From: Amanda Scholes on behalf of Planning.Responses
Sent: 30 April 2018 08:29
To: Amber Willard
Subject: FW: 56 North Lane Rustington
Attachments: North Lane 56-Block Plan.pdf; North Lane 56-PLANNING.pdf

From: Tim Murray [REDACTED]
Sent: 30 April 2018 08:22
To: Planning.Responses
Subject: 56 North Lane Rustington

DRAWING PLANNING DATE: MARCH 2018 DRAWN: T. Murray	SCALE 1/100 REVISION:

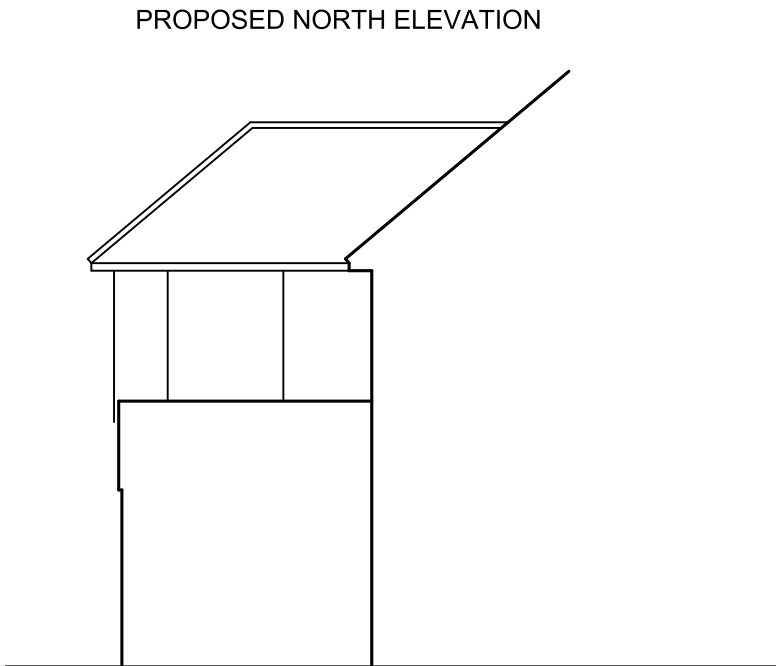
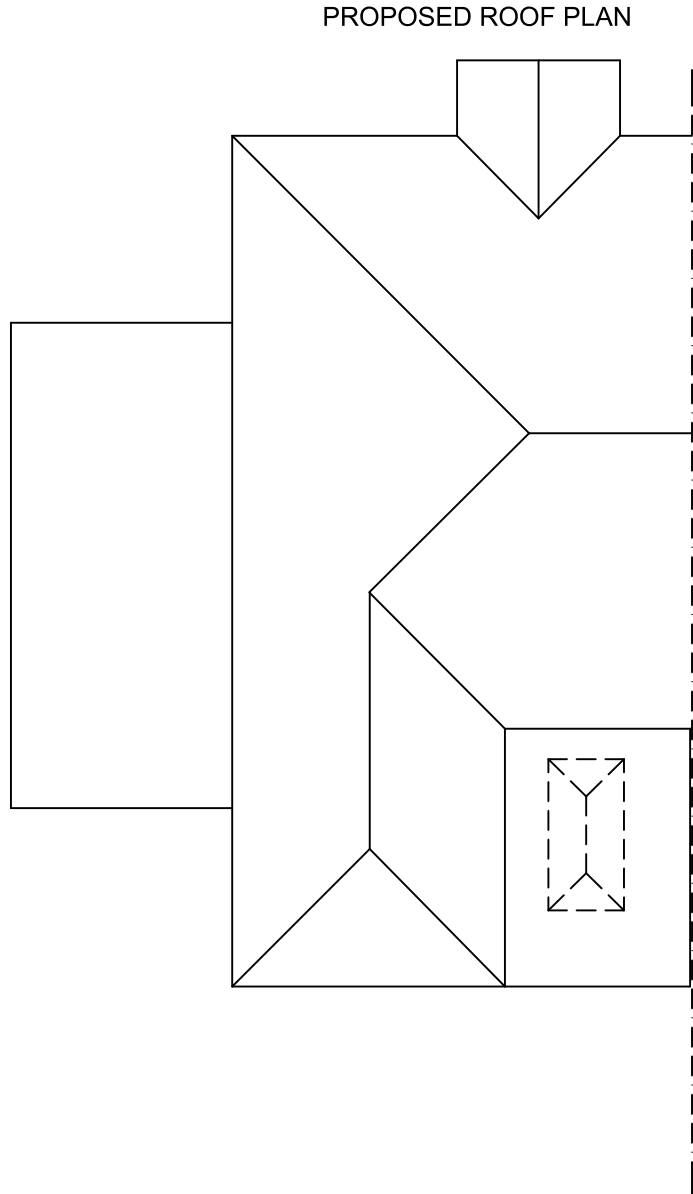
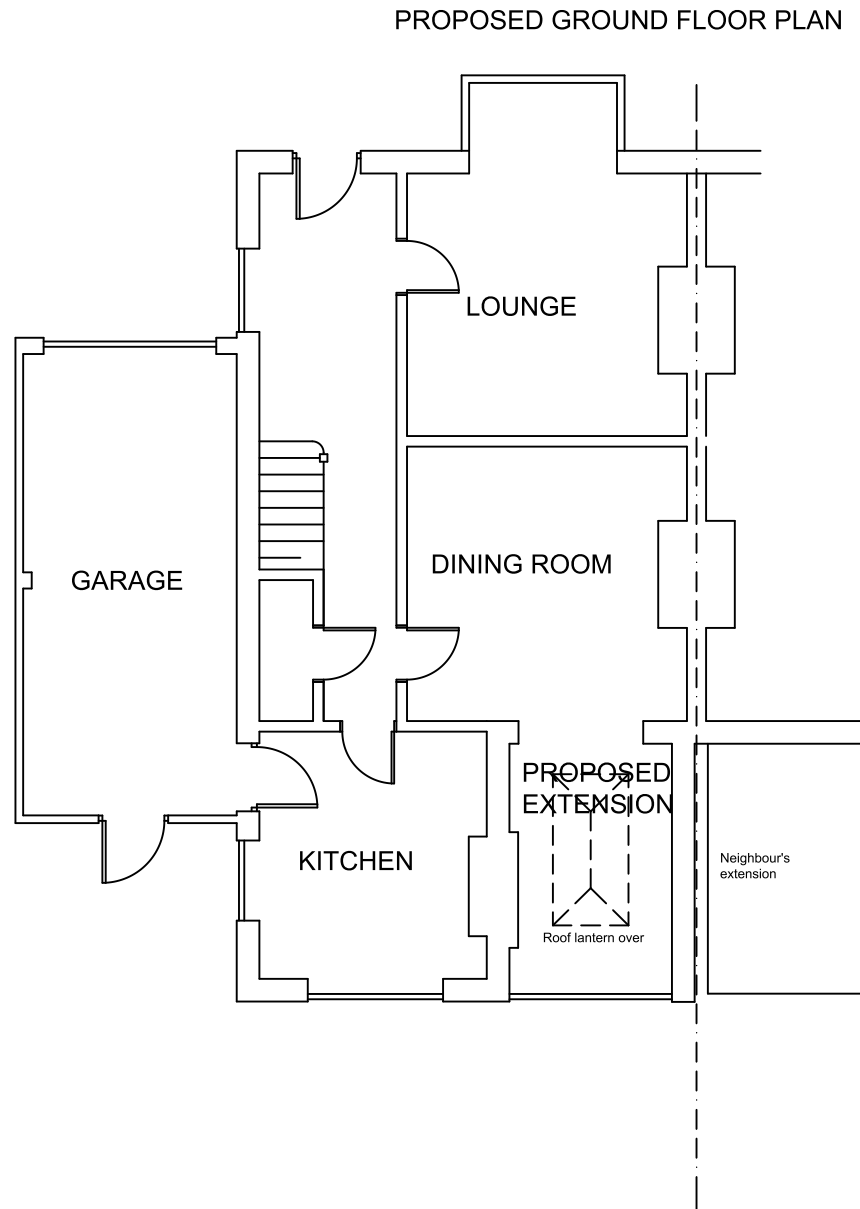
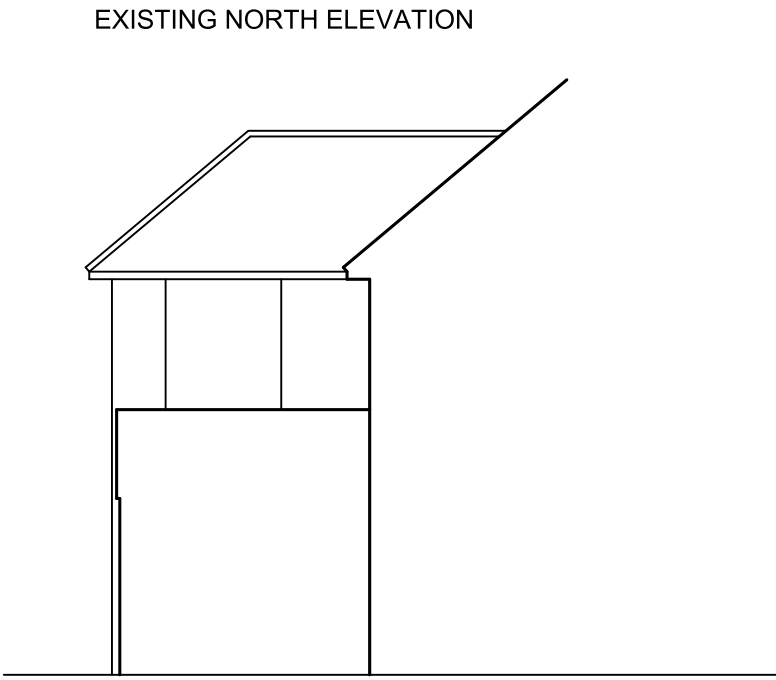
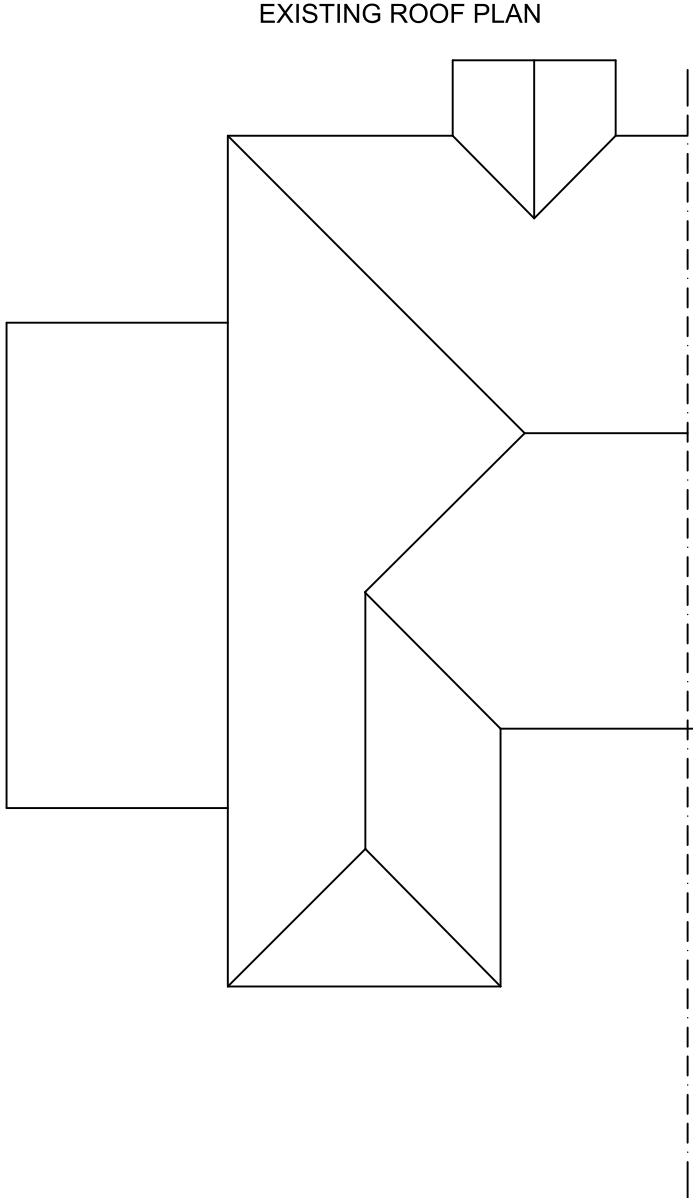
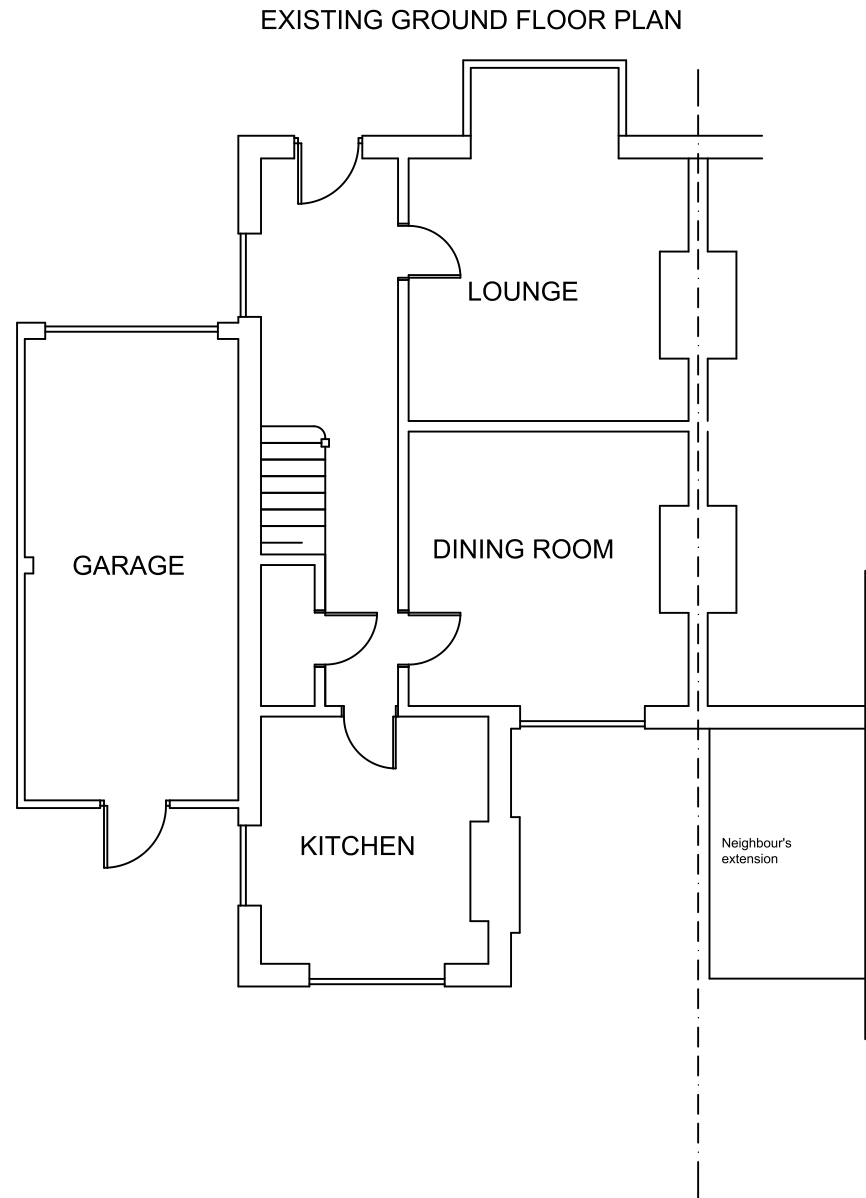
In response to concerns expressed by the neighbour, the client has decided to reduce the length of the proposed extension, and I therefore attach amended plan.
